Please treat as a substitute elevation plan

Please find attached a copy of the revised site plan, drawing number 20011/2.01 revision C and drawing 2.02 revision A. I would be grateful if you could substitute these for the previous versions.

Please can you let me have a revised site plan and elevation plan indicating native tree planting along the southern boundary as discussed, by Wednesday next week?

2.02

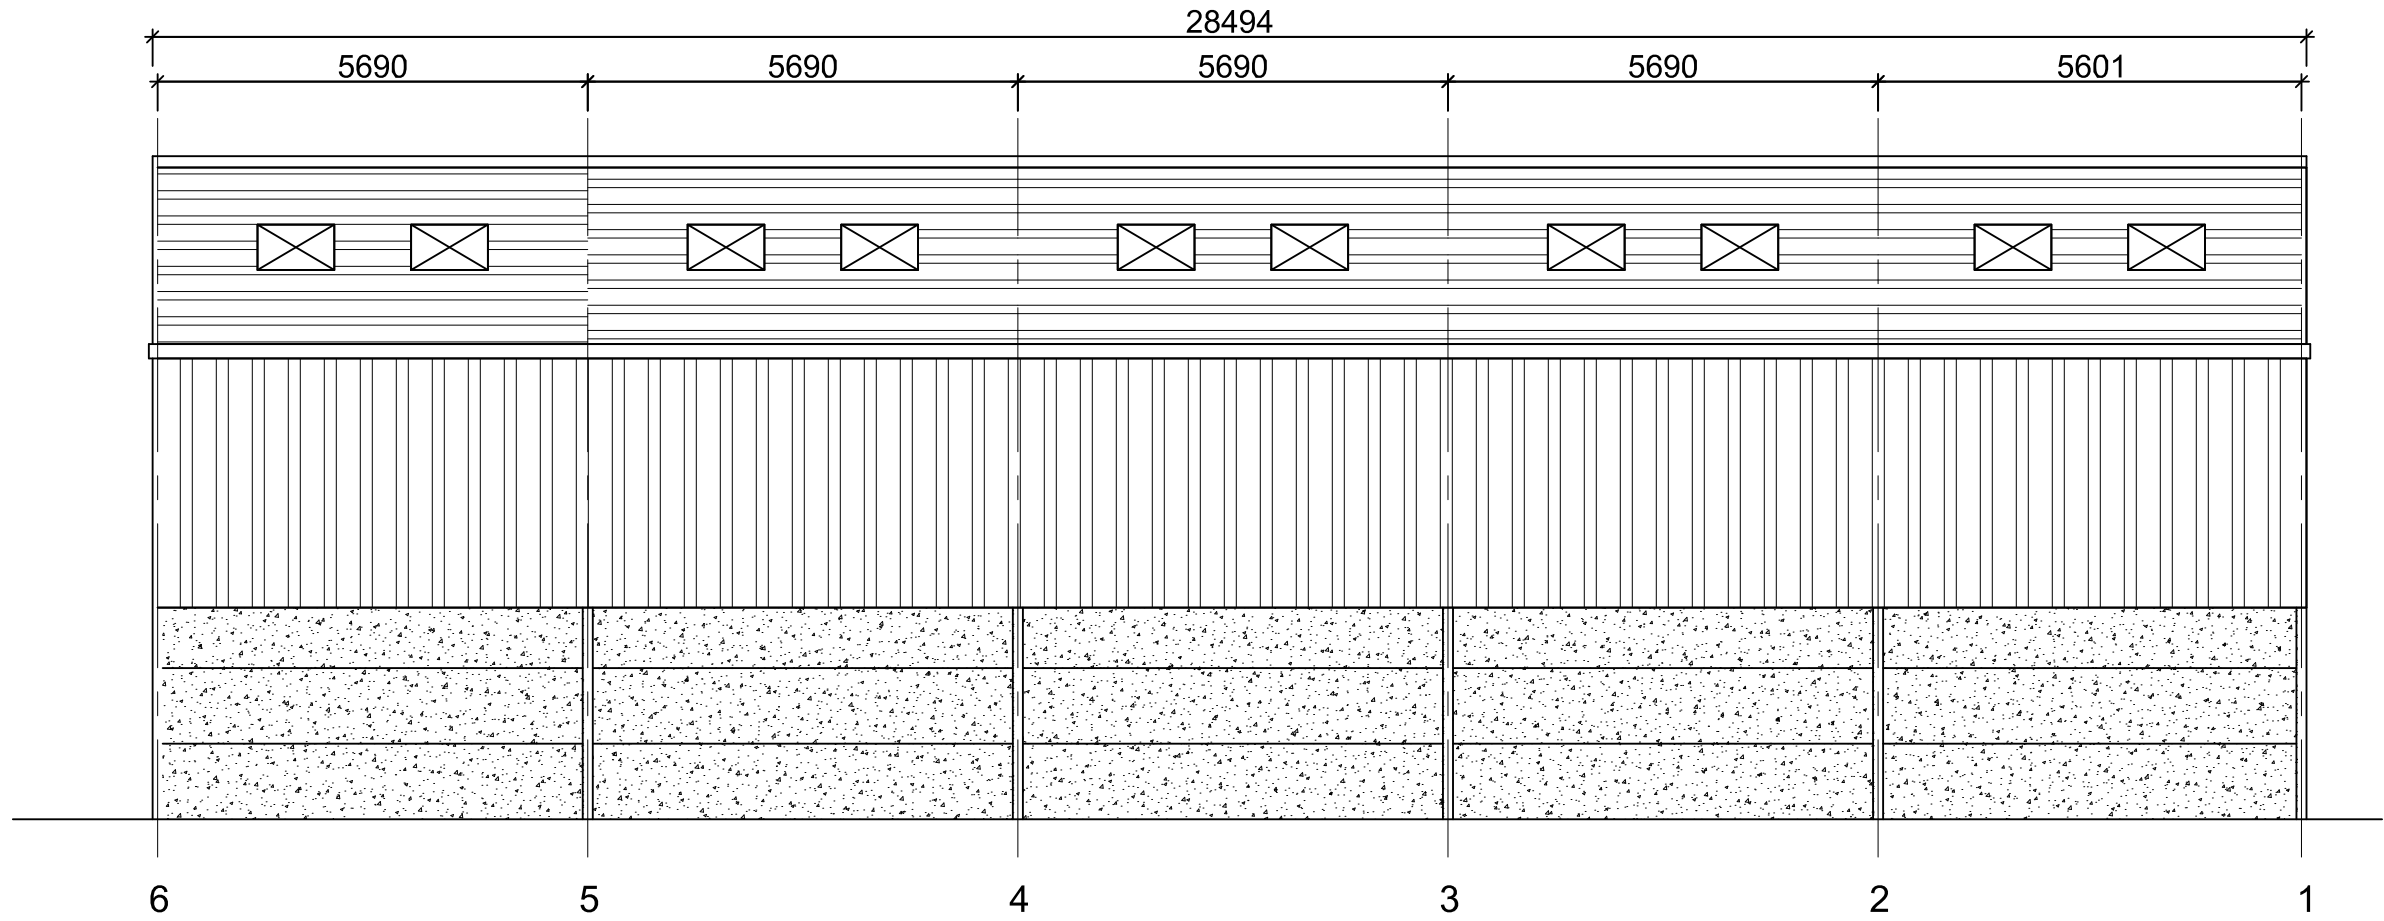
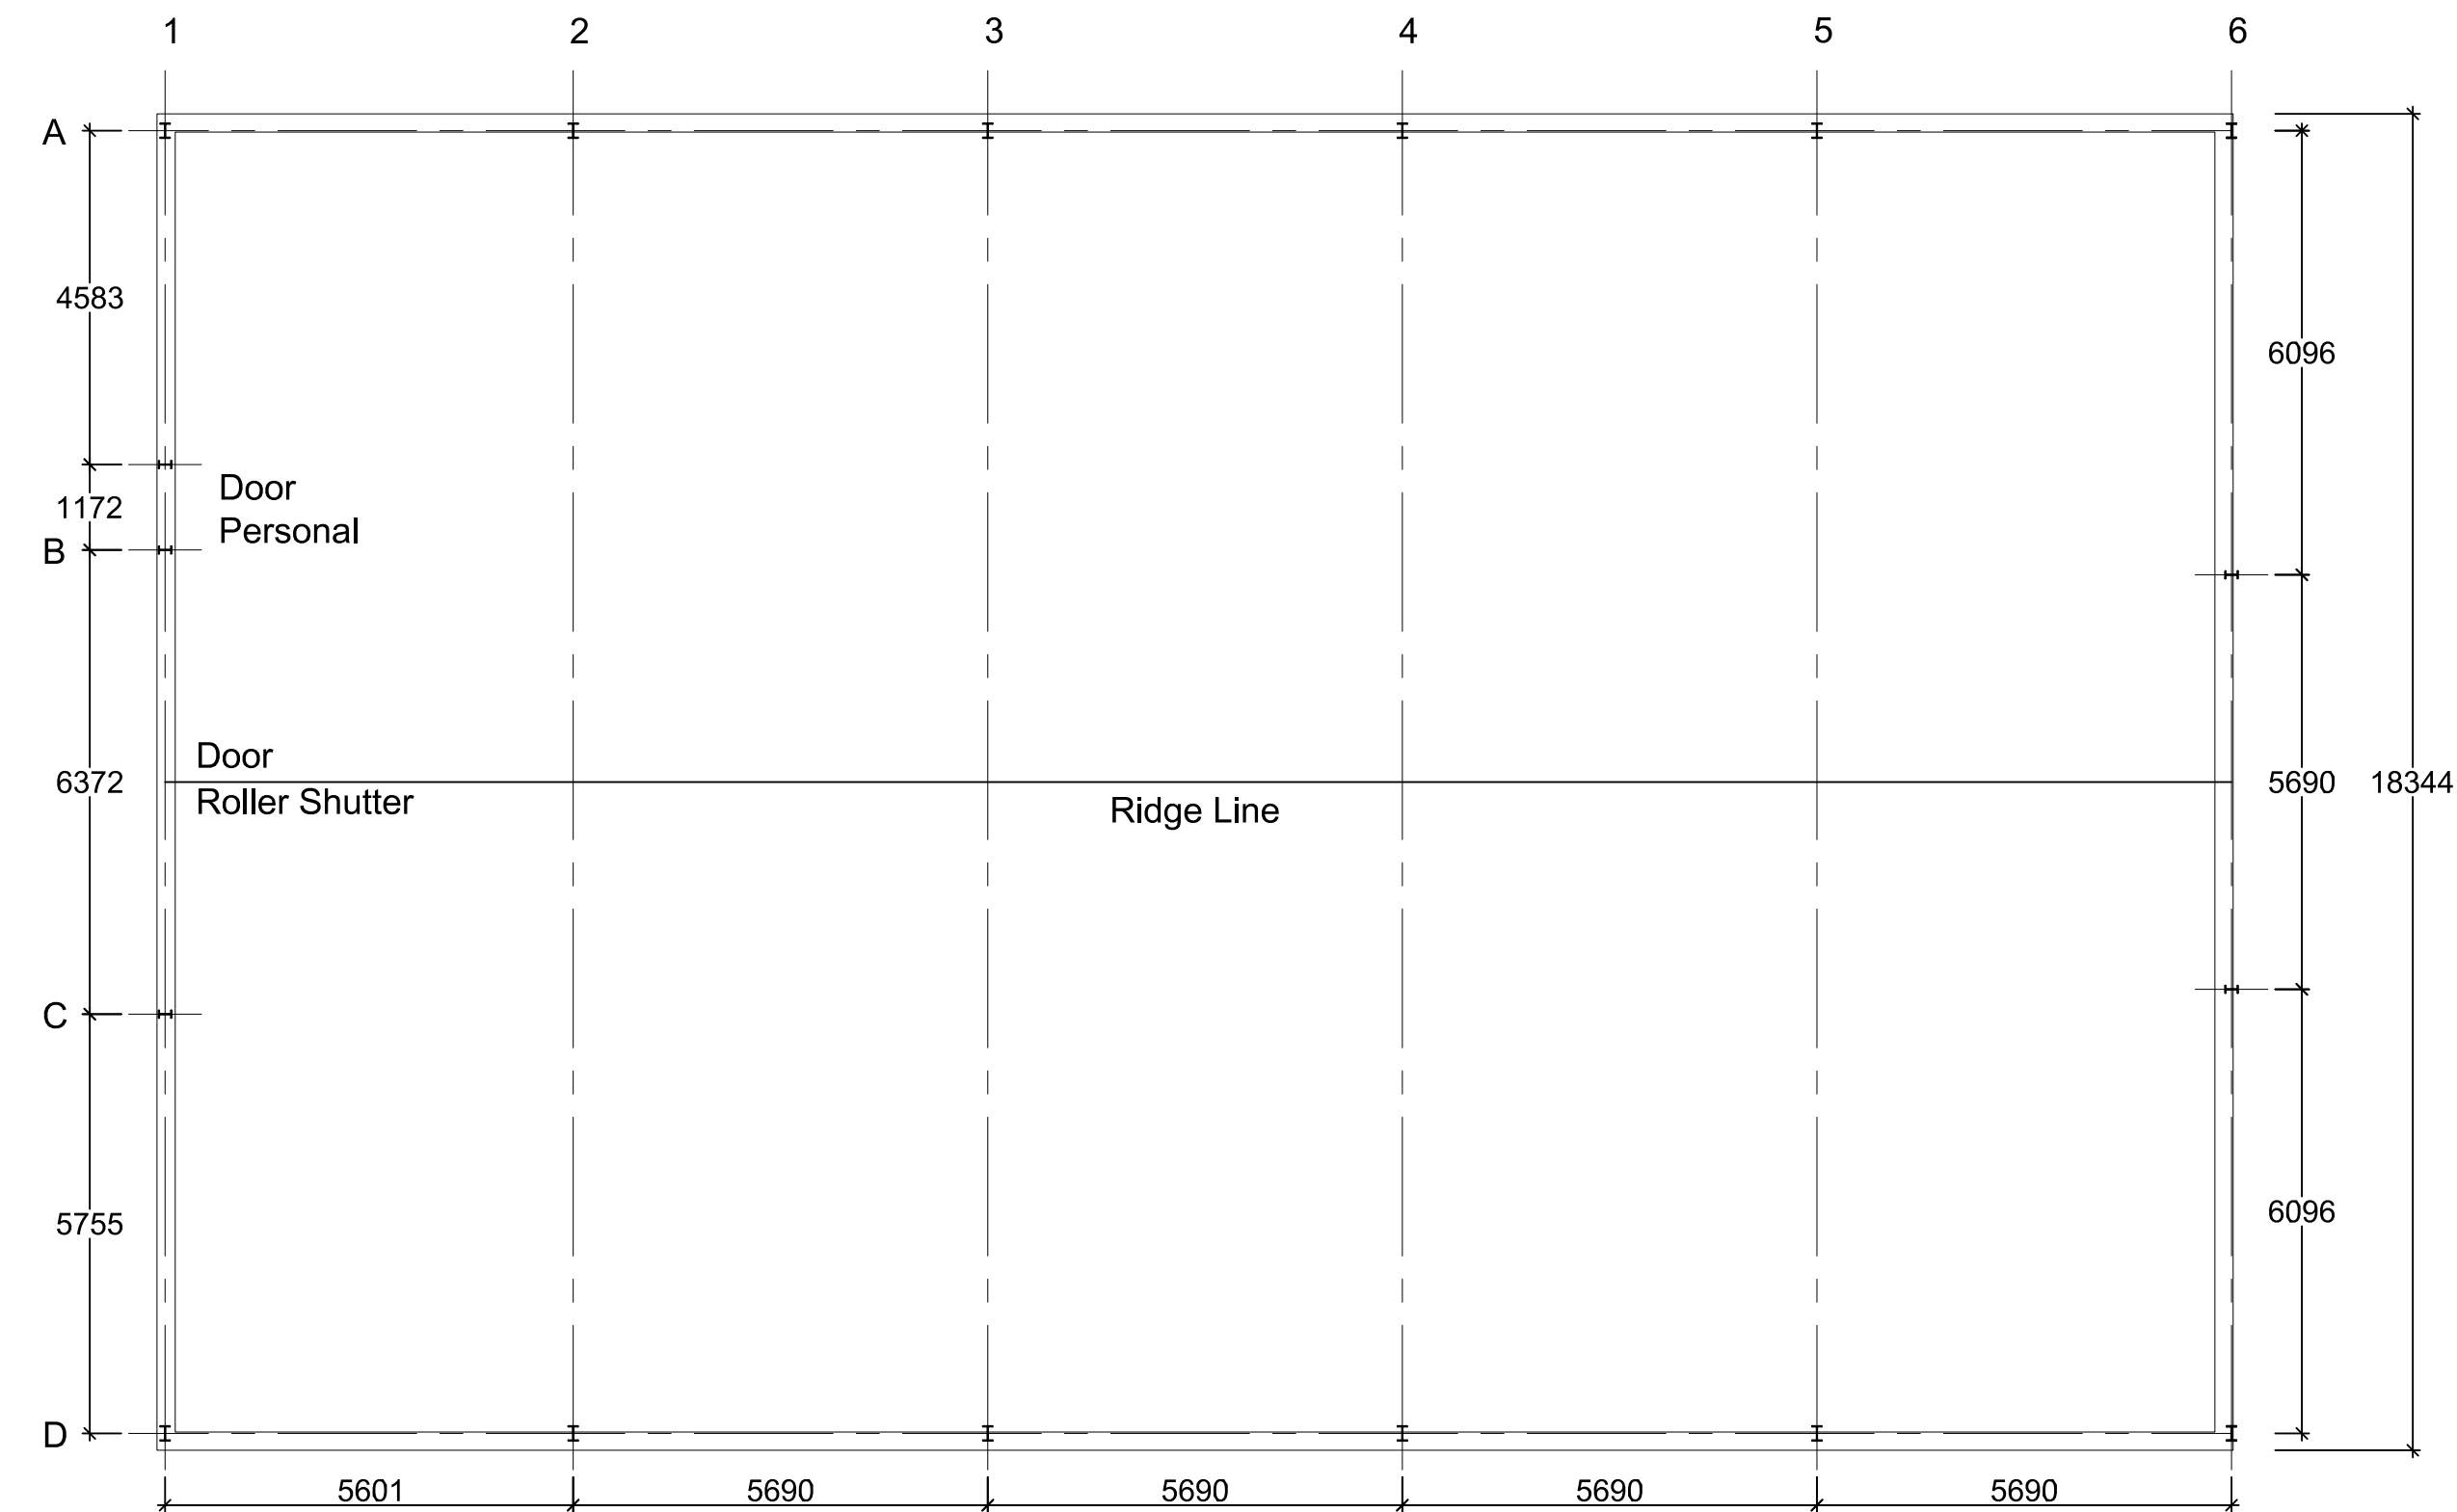
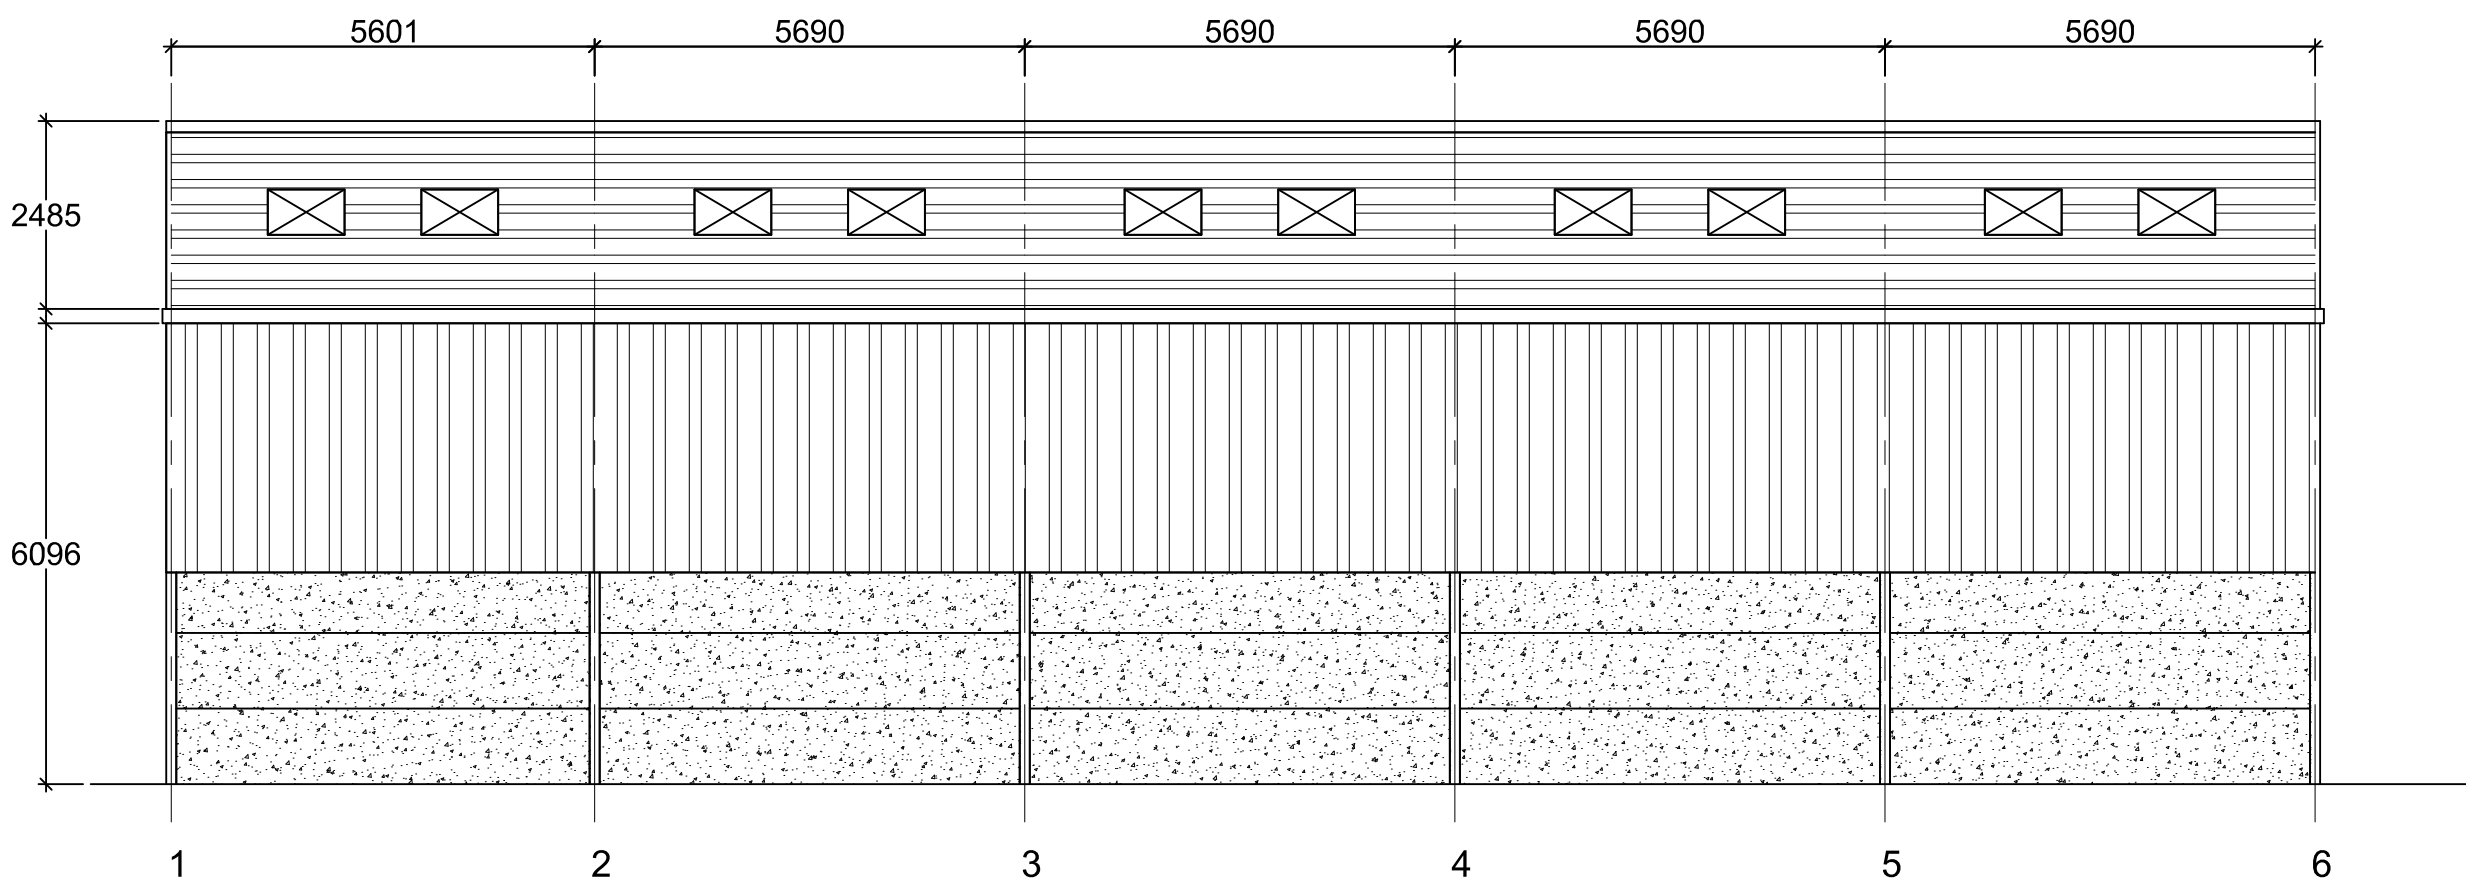
Is there no option to reduce the width/length of the building slightly so that tree planting can be included within the red edge? Or to move the building forward or sideways within the red edge? A reduction in size would help to address our concerns and those of the Parish.
